Meeting Minutes - Peer Review Process: Architecture Design Review Panel

Rozelle Village

Redevelopment of Balmain Leagues Club - Victoria Road, Waterloo Street and Darling Street, Rozelle

Date:	10 November 2011
Meeting No:	Meeting 2: Design Development Presentation
Location:	Rozelle Village Information Centre, Rozelle
Time:	8.00am
Attendees:	Panel Members Ken Maher (KM) – Chairman, Hassell Professor Alec Tzannes (AT) – Director, Tzannes Associates Helen Lochhead (HL) - NSW Deputy Government Architect Tony Caro (TC) – Director, Tony Caro Architects Property Developers Ian Wright (IW) - Rozelle Village Pty Ltd Architects Frank Stanisic (FS) - Stanisic Associates Jason Nowosad (JN) - Stanisic Associates (scribe)
Apologies:	Alex Yasumoto (AY) - Rozelle Village Pty Ltd
Attachments	Design Development Presentation

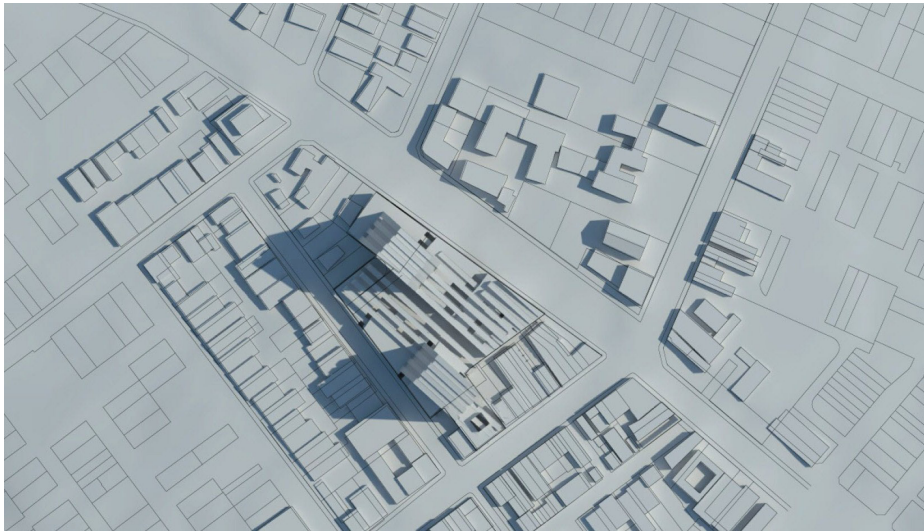
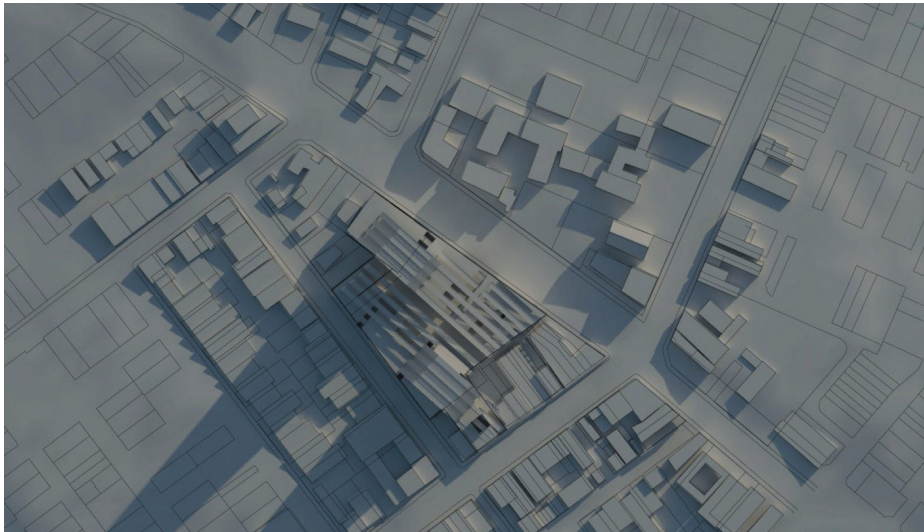
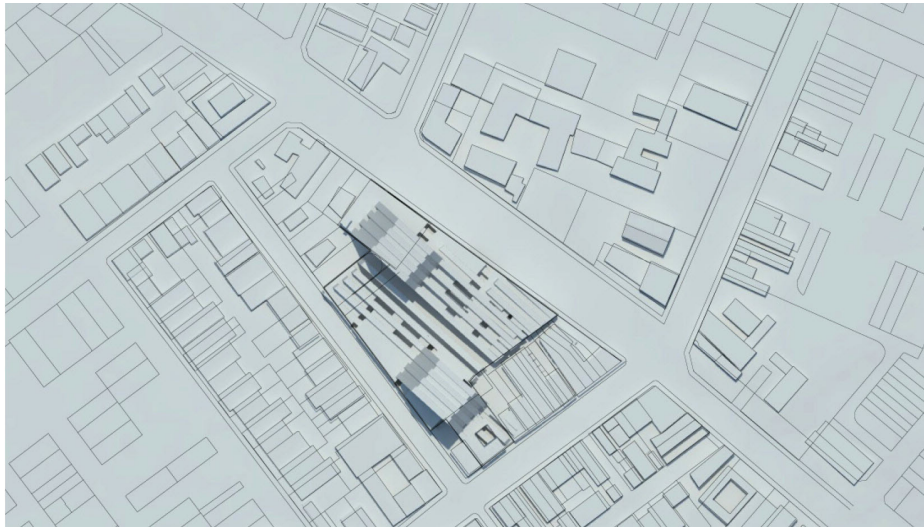
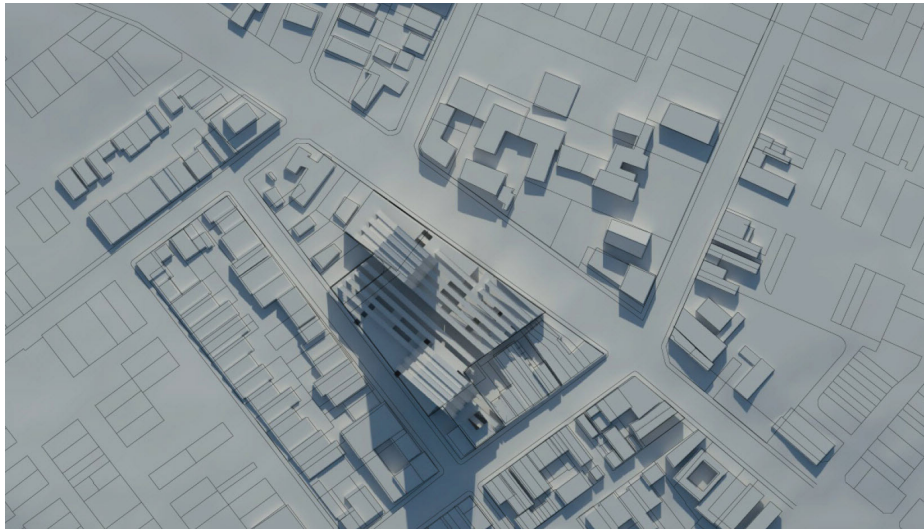
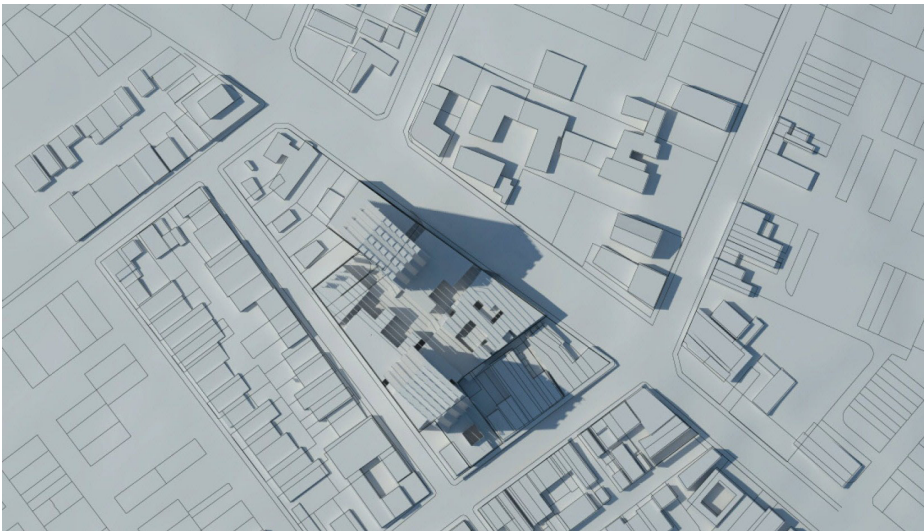
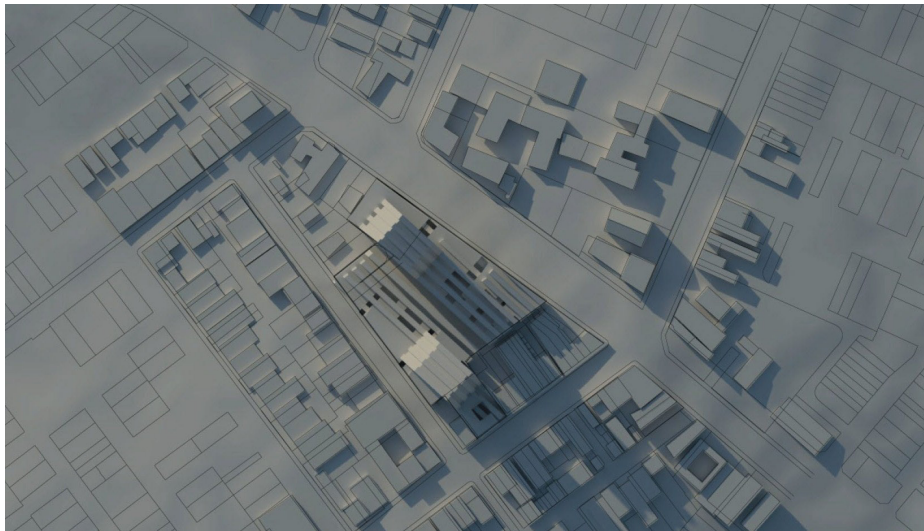
- AT commented that the overshadowing studies appear promising.
- TC questioned the location of the north point on the base drawings. FS agreed to confirm the north point and overshadowing diagrams.

- HL requested confirmation whether there is any additional overshadowing that is unreasonable. FS said he will investigate.
